Arun District Council
Arun Civic Centre
Maltravers Road
Littlehampton
West Sussex BN17 5LF
Planning & Building Control General
Enquiries
Tel: (01903) 737756 Fax: (01903) 730442
Dx: 57406 Littlehampton
Minicom: 01903 732765
e-mail: planning@arun.gov.uk
website: www.arun.gov.uk/planning
Our Ref: FP/121/11/
Your Ref:

14th July 2011

**Two storey rear extension. Gable extension to front to include 2 balconies. Re-submission following FP/6/11/
Seacroft Outram Road Felpham Bognor Regis**

Proposed Side Elevation

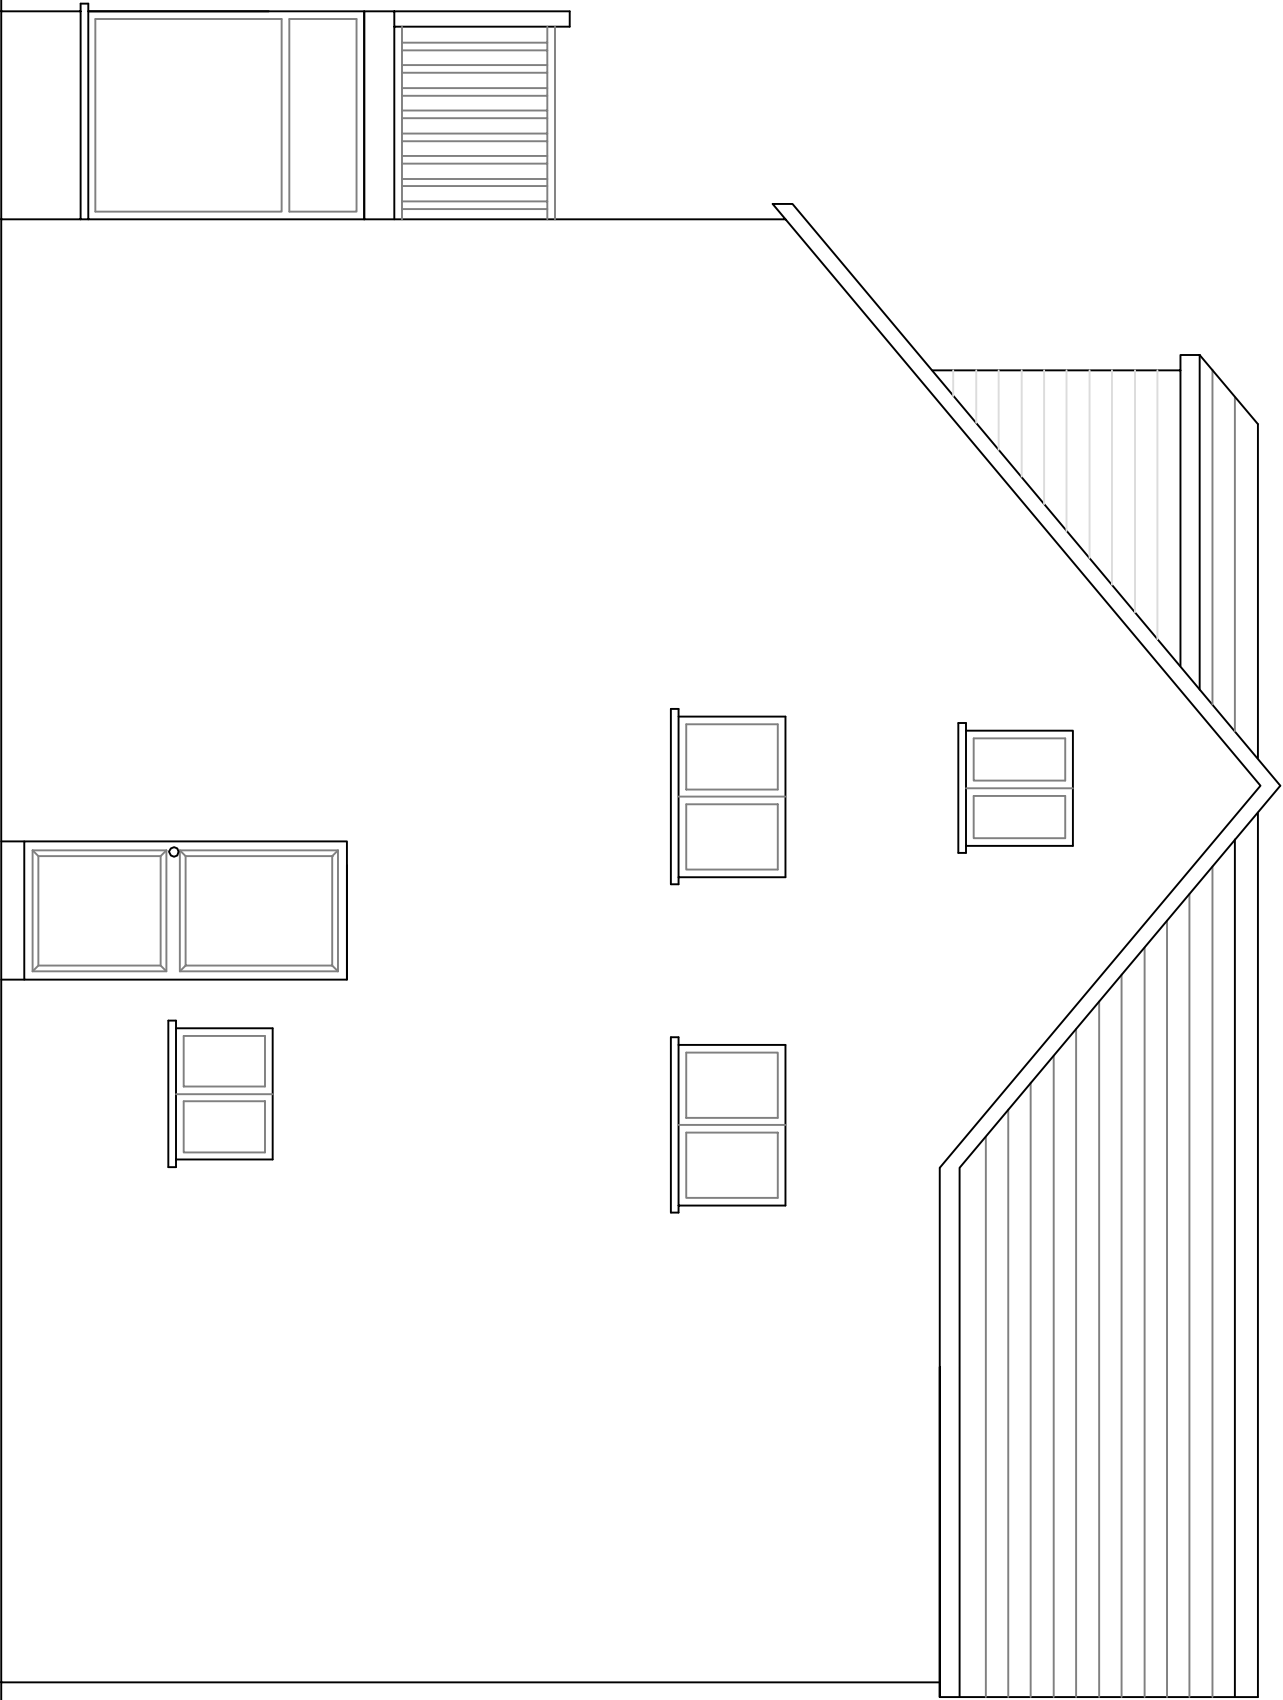
Please provide 1 electronic or 3 paper copies of a proposed ground floor plan and a revised proposed second floor plan to show the window detailed on the side elevation.

Seacroft Outram Road

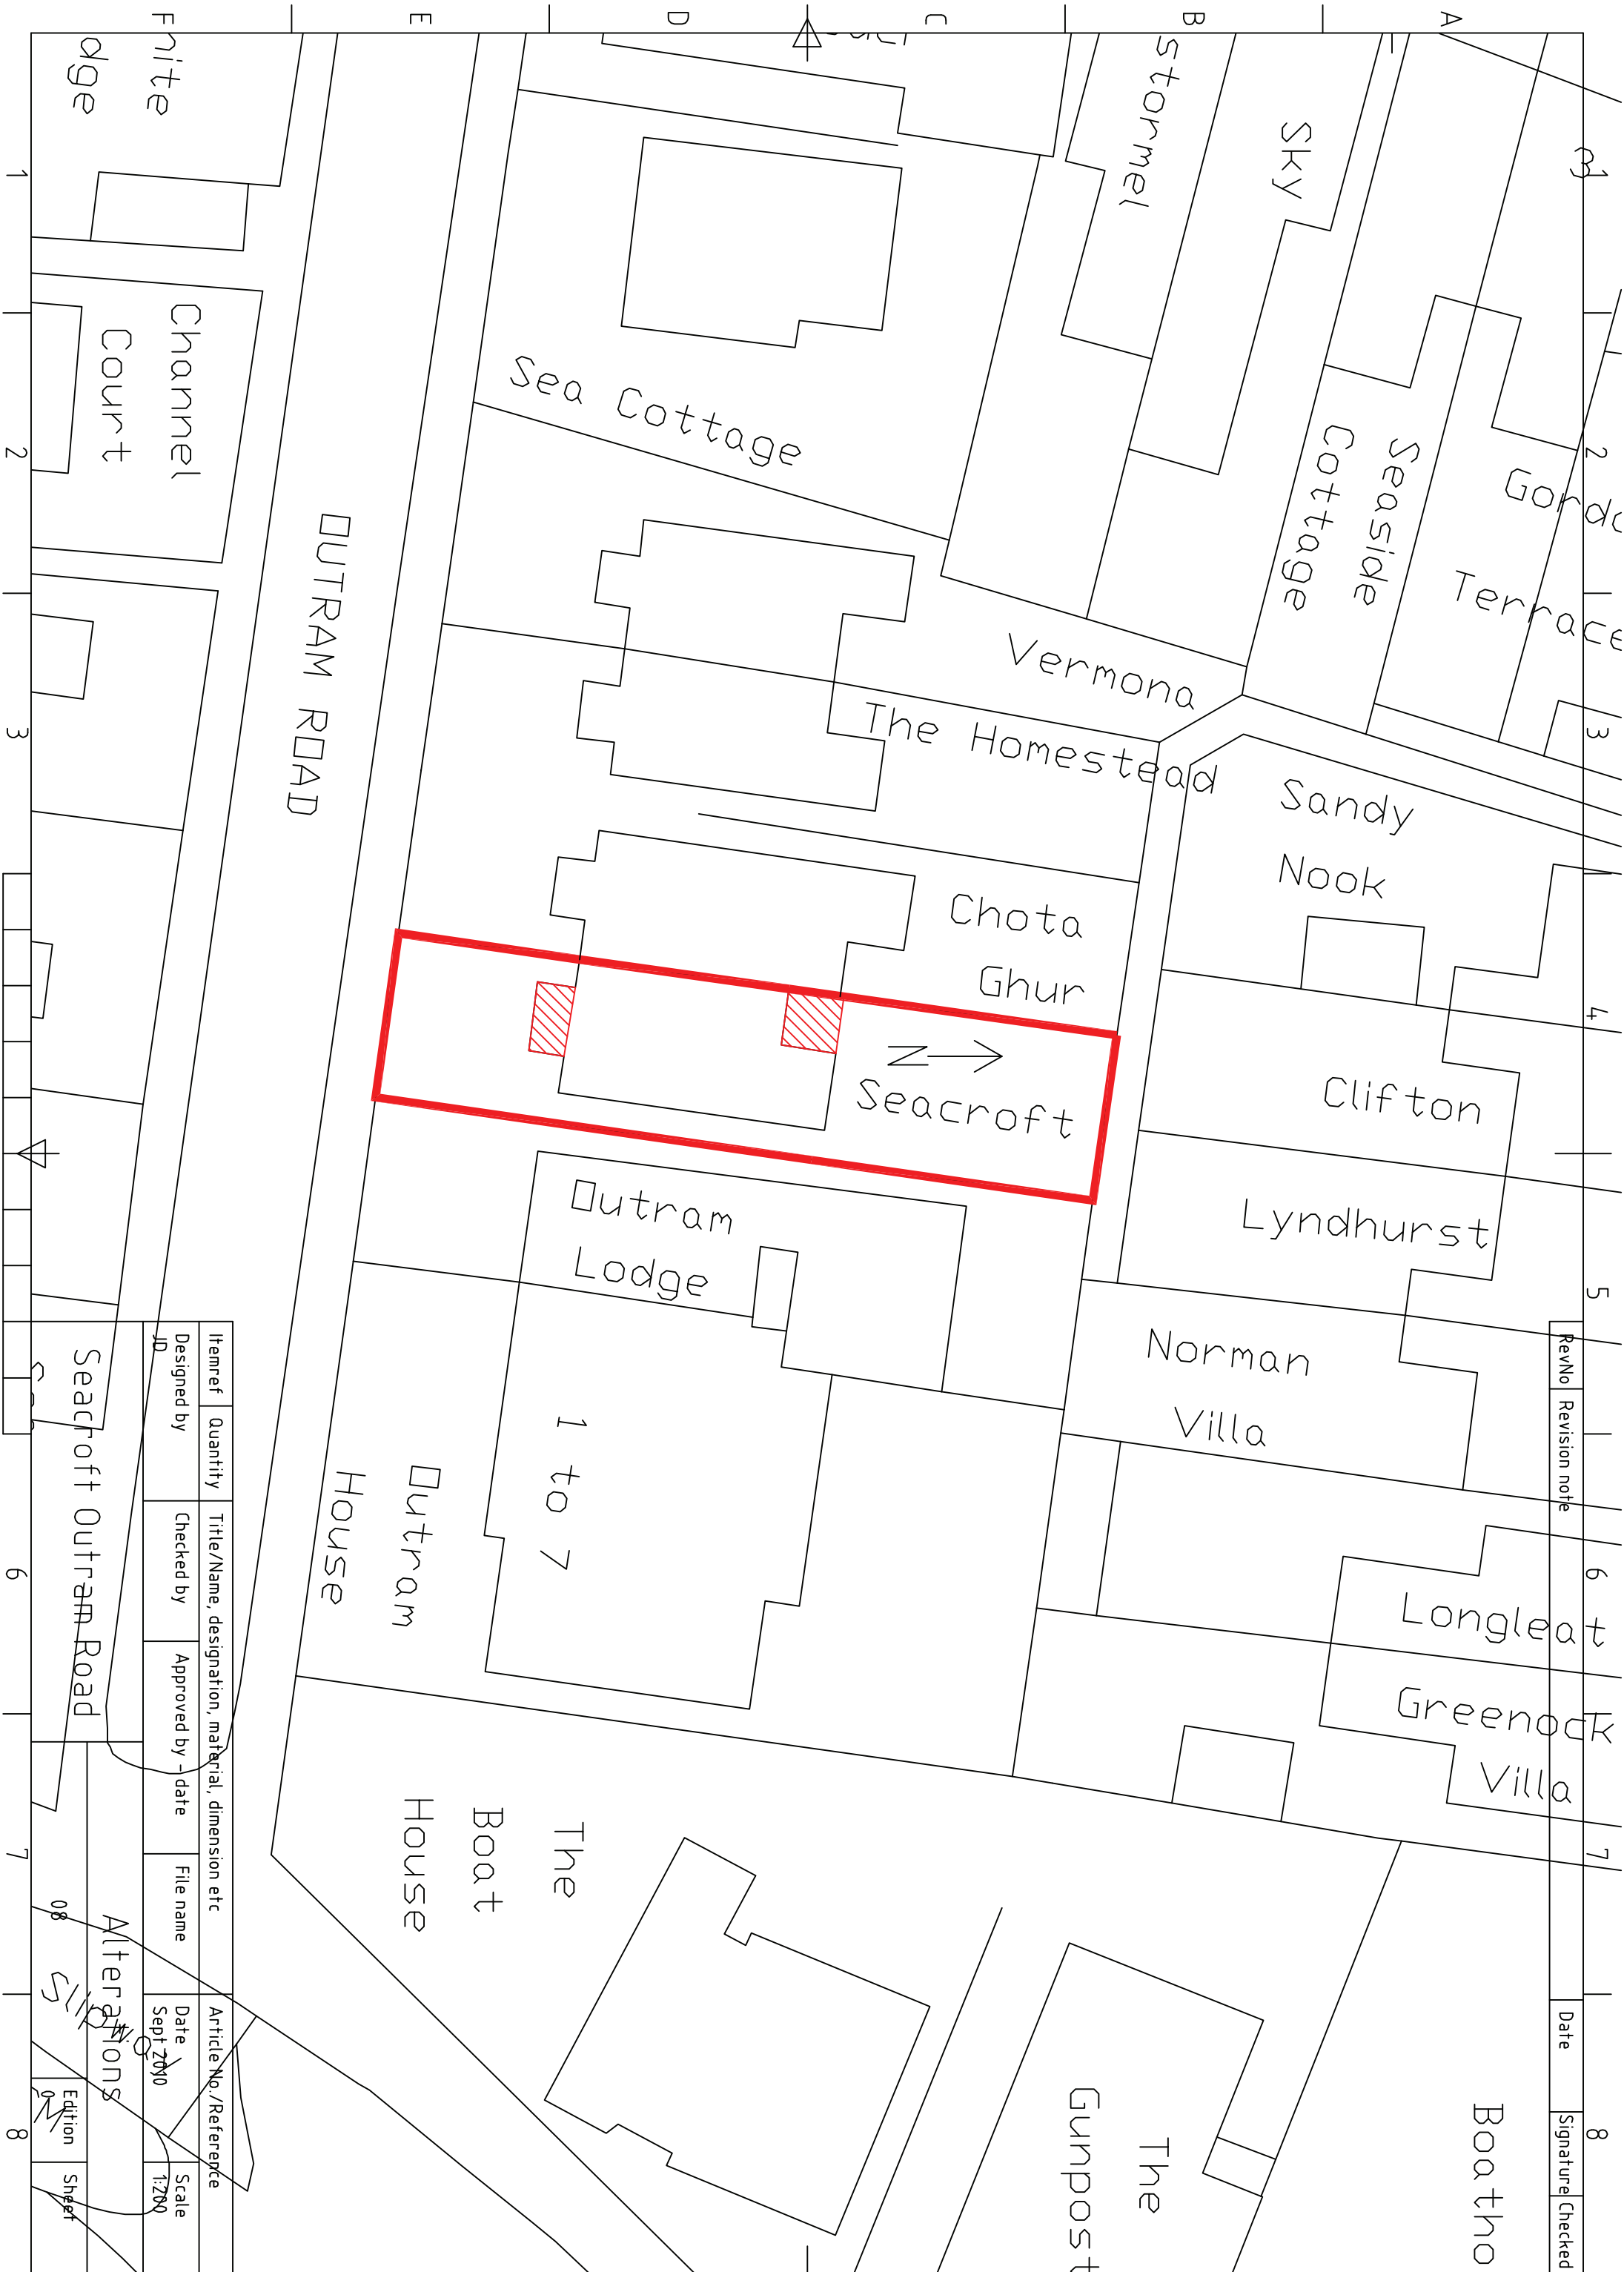
I require 1 electronic or 3 paper copies of revised block/site plans (1:500 & 1:200) to show the proposed works on the front elevation as well as the rear, in accordance with the guidance notes available on our website detailed below (click on National List).
